Final Report - Corrections Required **Application No. DEPN-24-0160**

Description : Multi-family development with 170 rental duplex units on one development lot. Also a request for alternate landscape compliance related to placement of streamside overly and property boundary buffer plantings, and to be allowed to provide 9.4% active open space where 10% is required.

Address : 2210 Old Ranch RD Colorado Springs CO 80920

## SITE PLAN

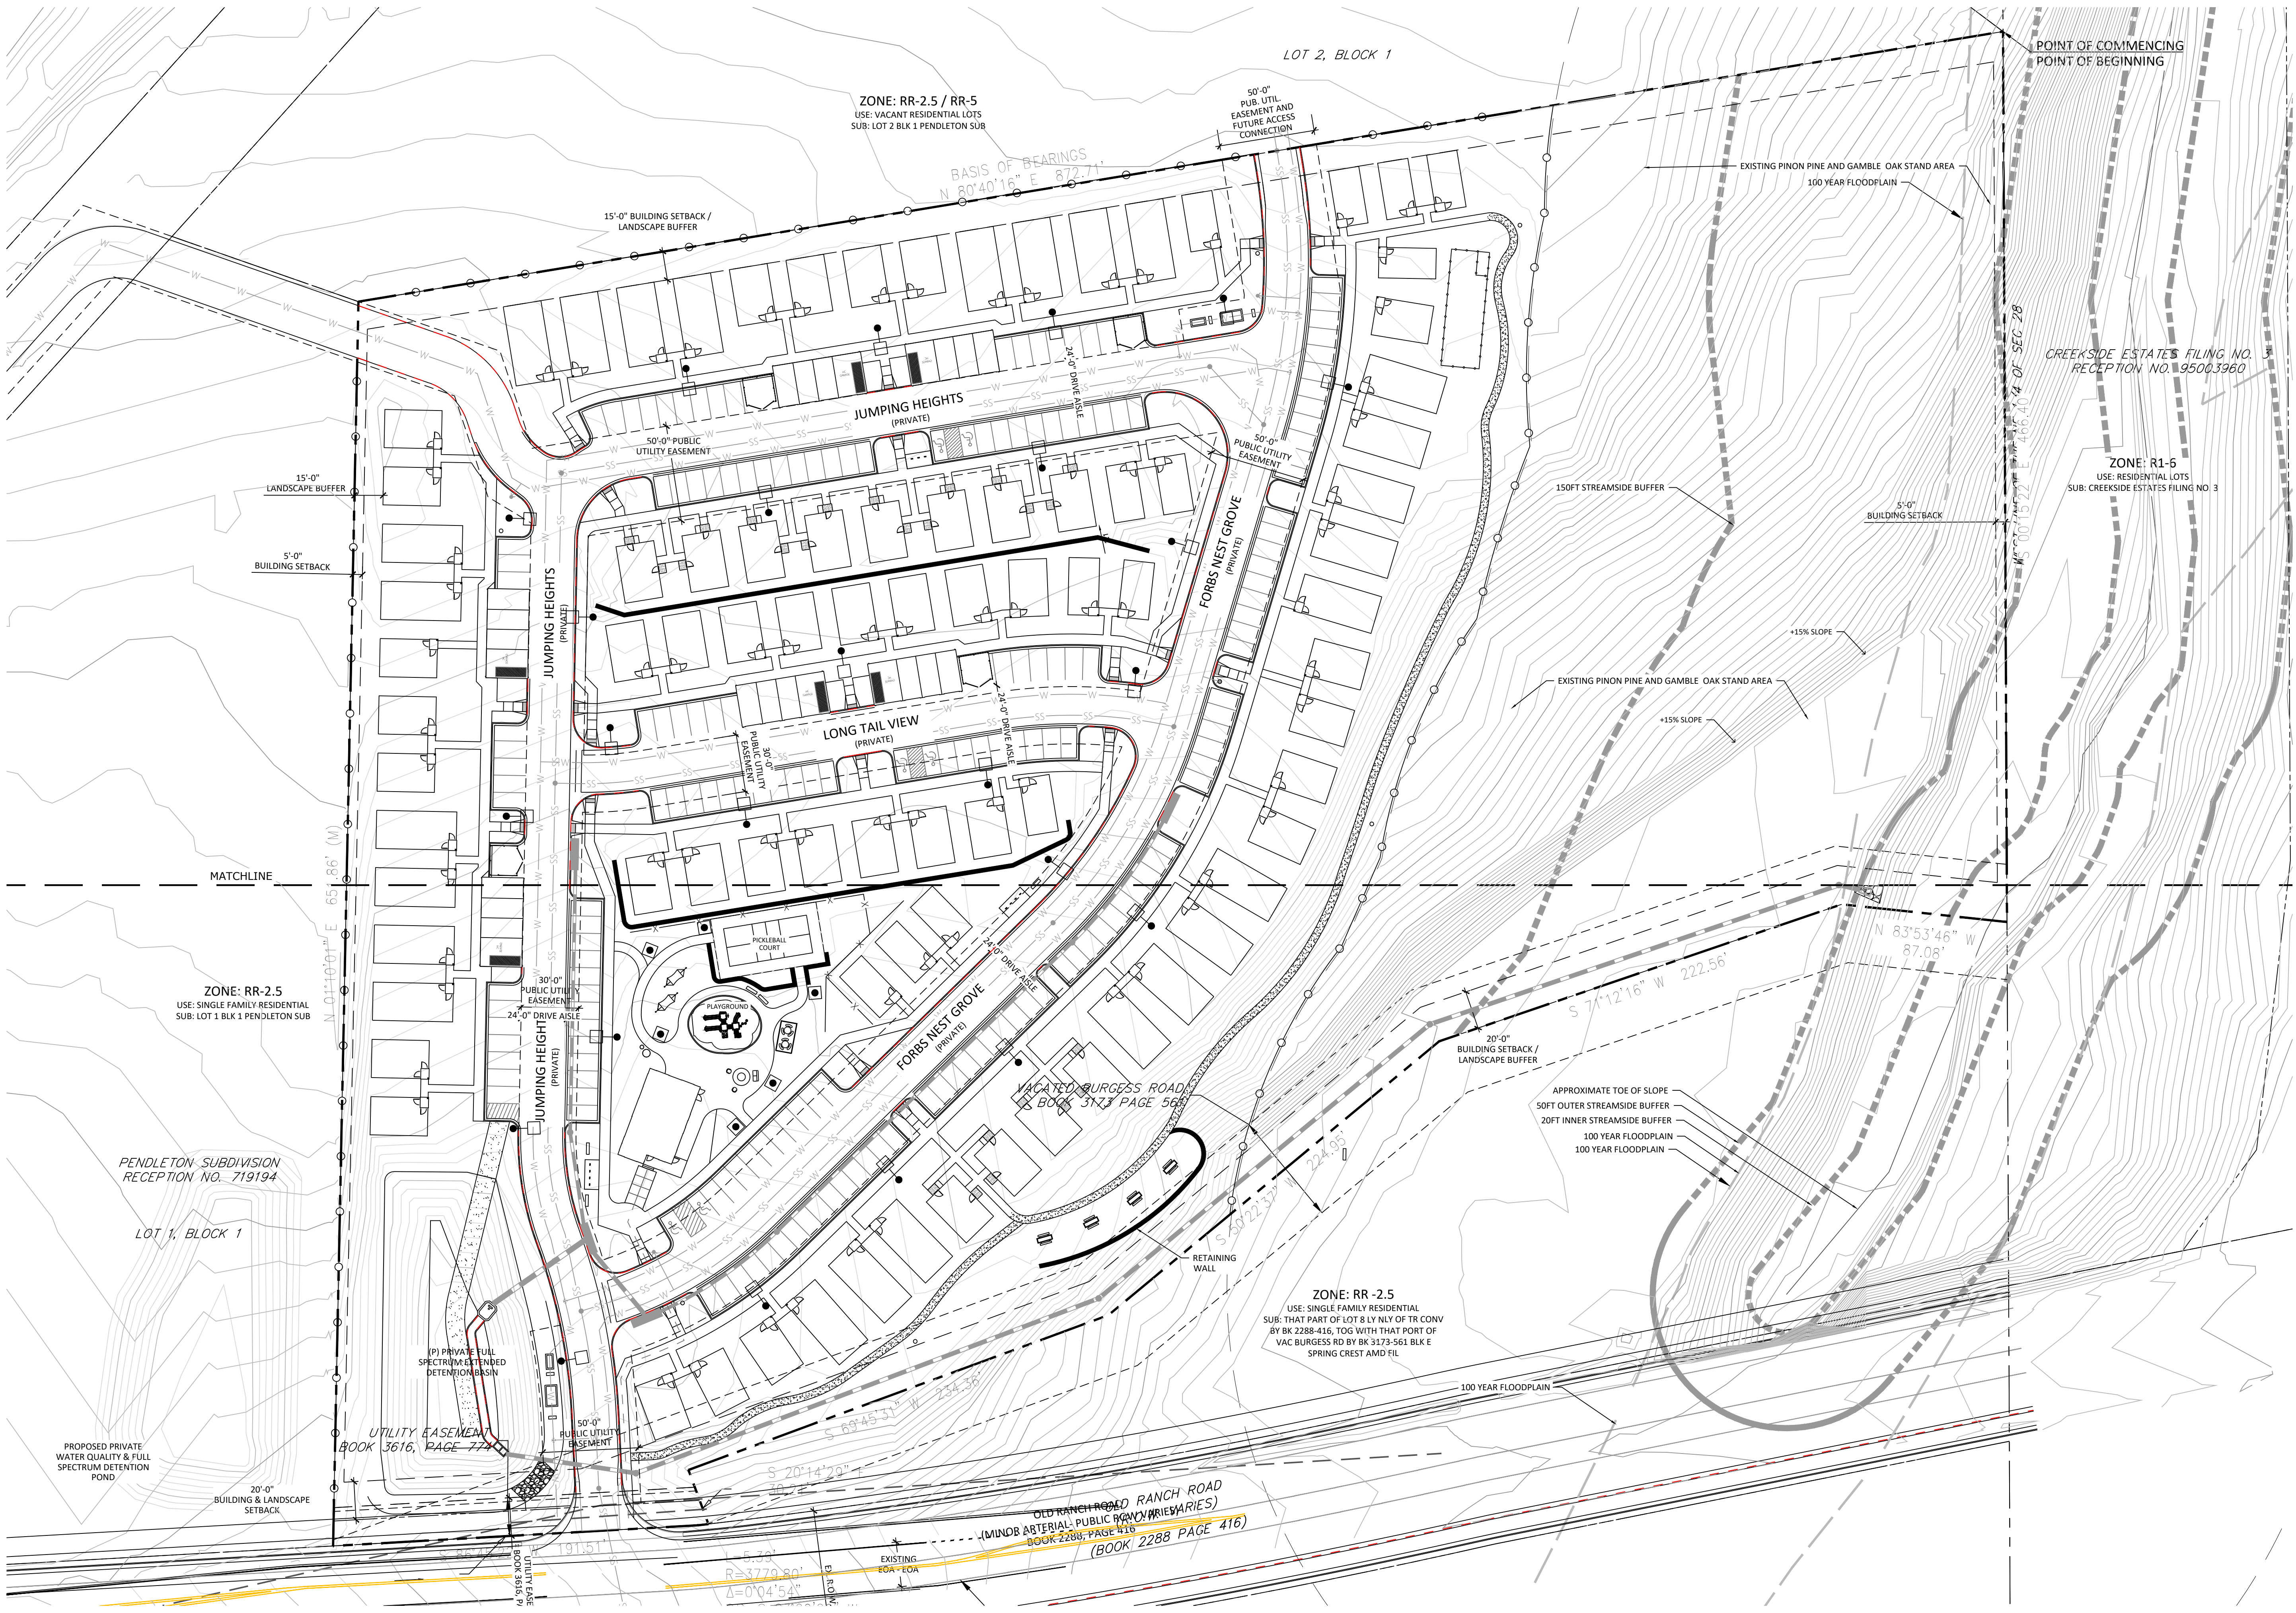
Comment ID	Reviewer : Department	Review Comments
		<p>4. I am only seeing 6 garages not 7. Please label the 7th.</p> <p>5. Regarding the shaded seating area, how is it shaded? Gazebo, canopy?</p> <p>6. Each duplex structure will be assigned a single address with unit numbers 101 & 201. Contact me when you are ready to have the area addressed.</p> <p>Amy Vanderbeek Enumerations Plans Examiner Pikes Peak Regional Building Department O: 719-327-2930 E: Amy@pprbd.org</p>

## STREAMSIDE CRITERIA

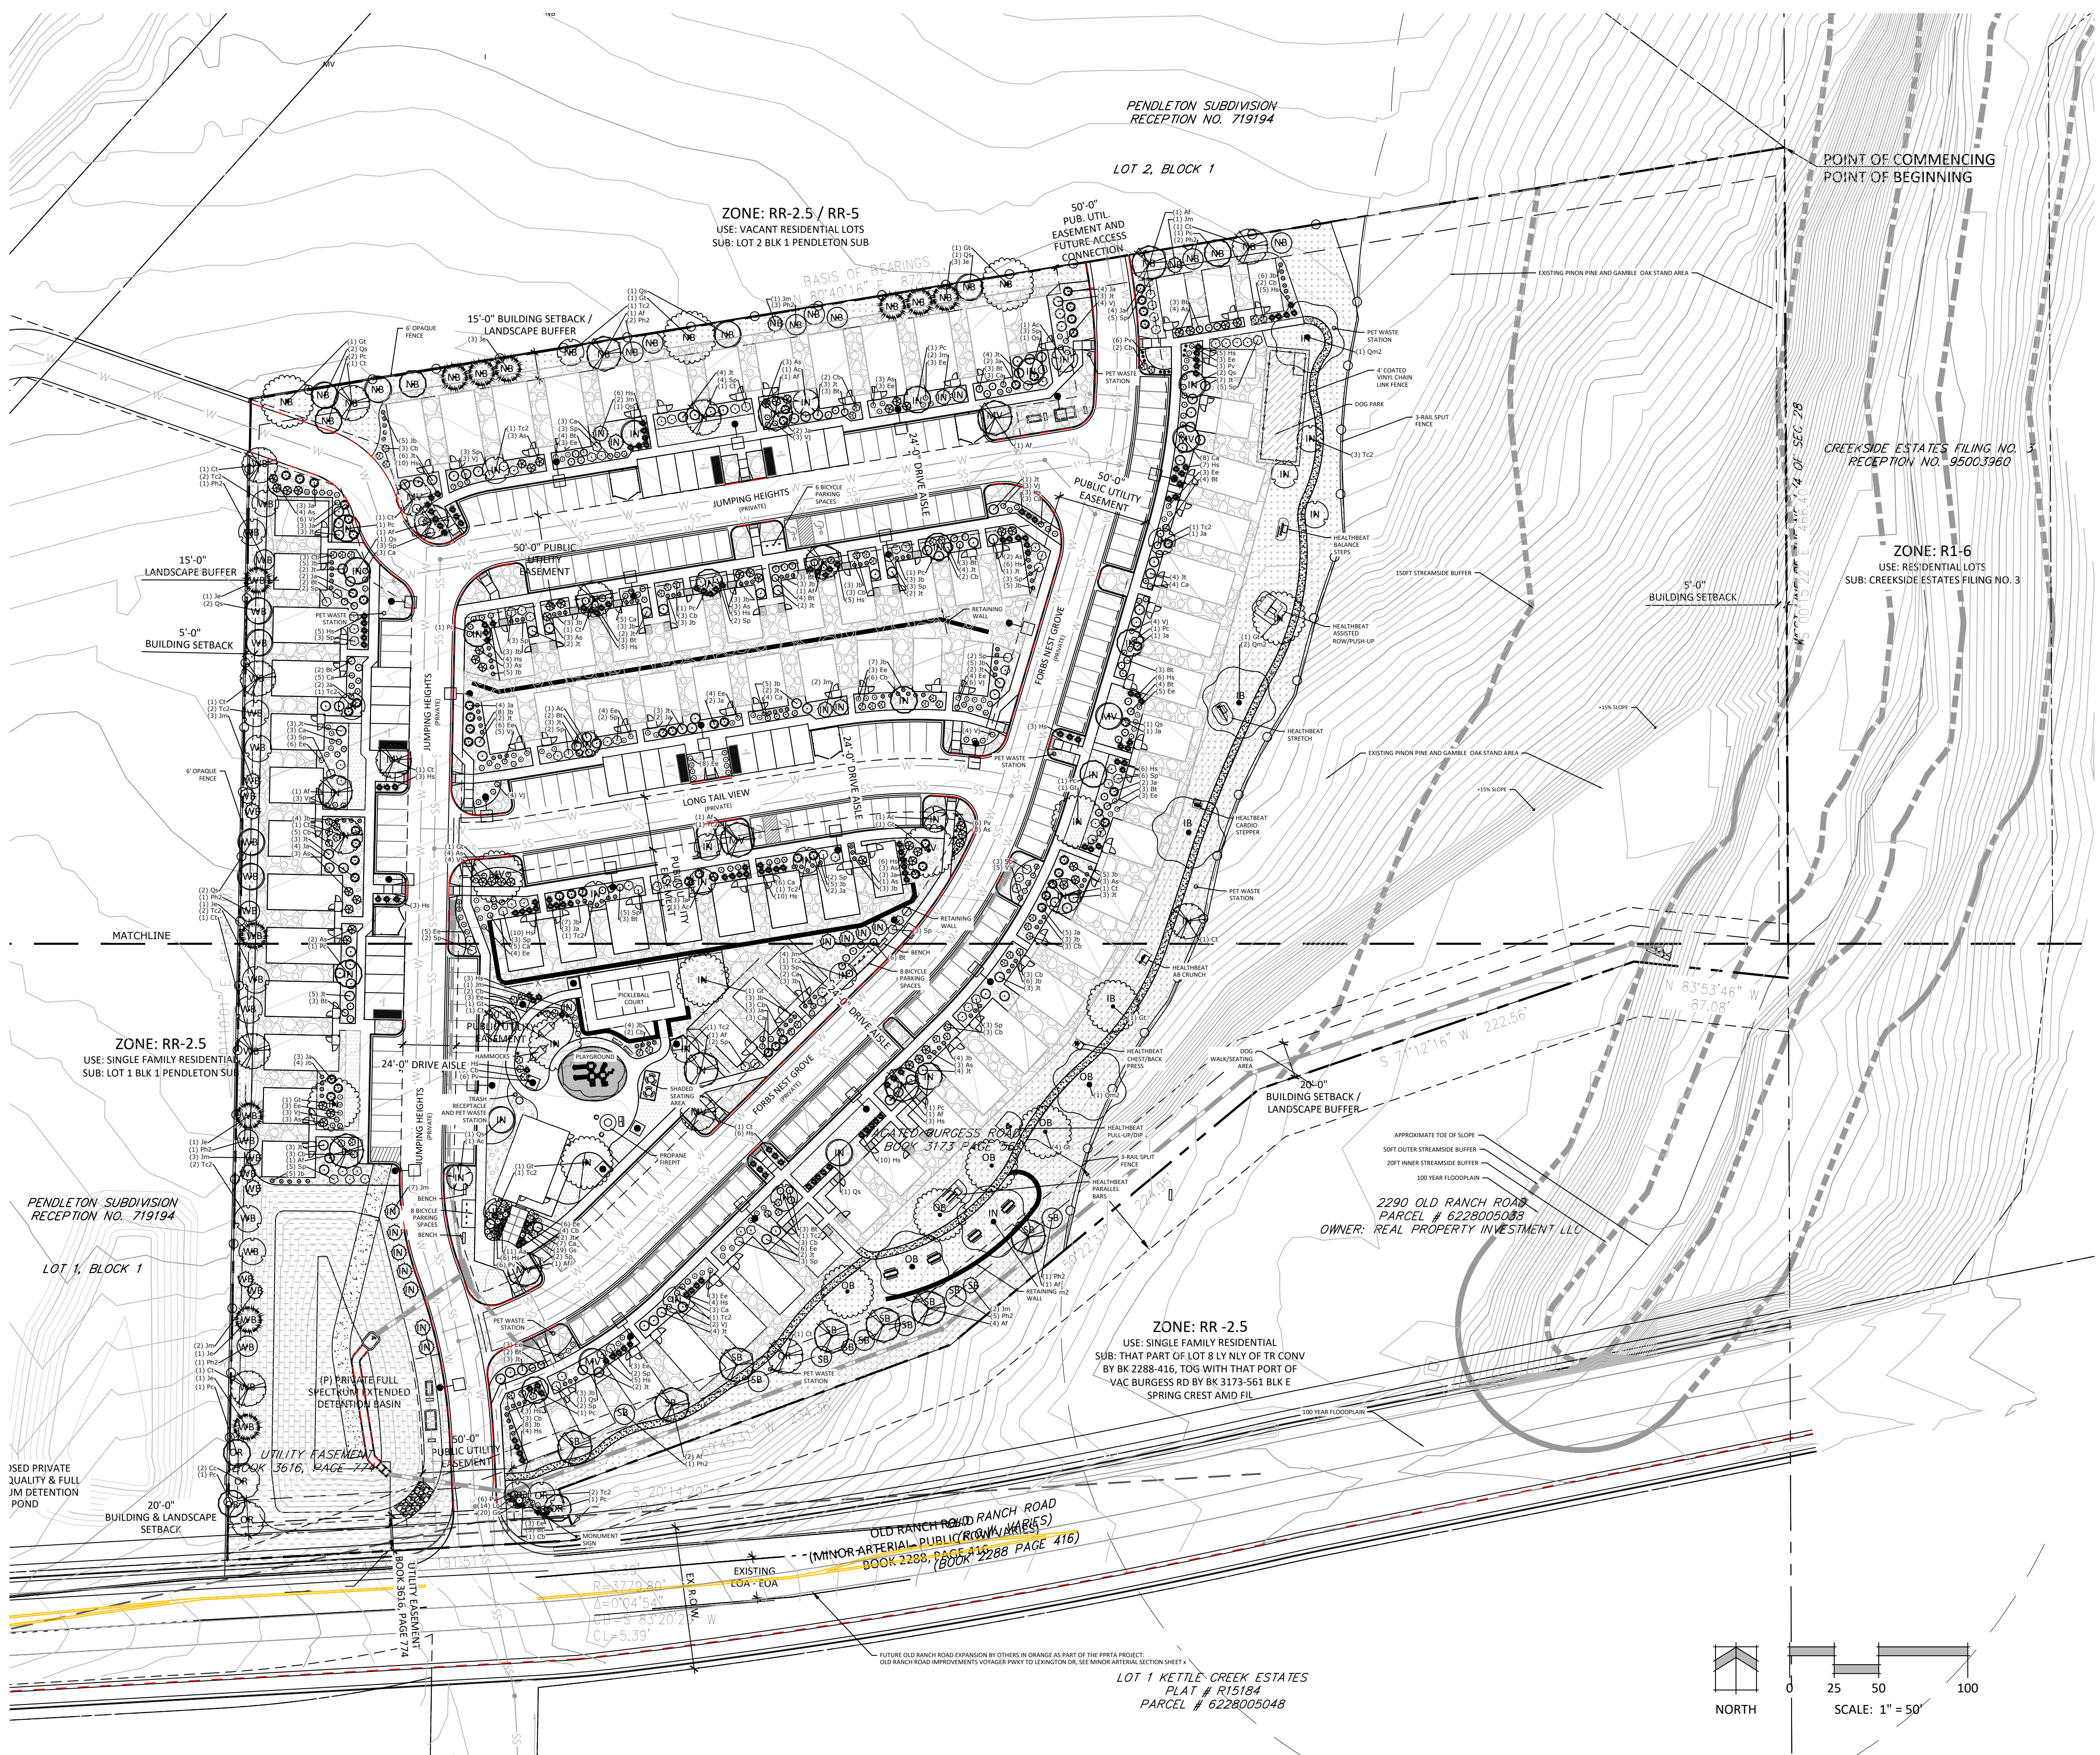
Comment ID	Page Reference	Reviewer : Department	Review Comments
19	10	Allison Stocker : Planning	I thought that all SS-O plantings were to be within the residential development? Or are these intended to make up for any disturbance to the stream as a result of the added storm pipe?
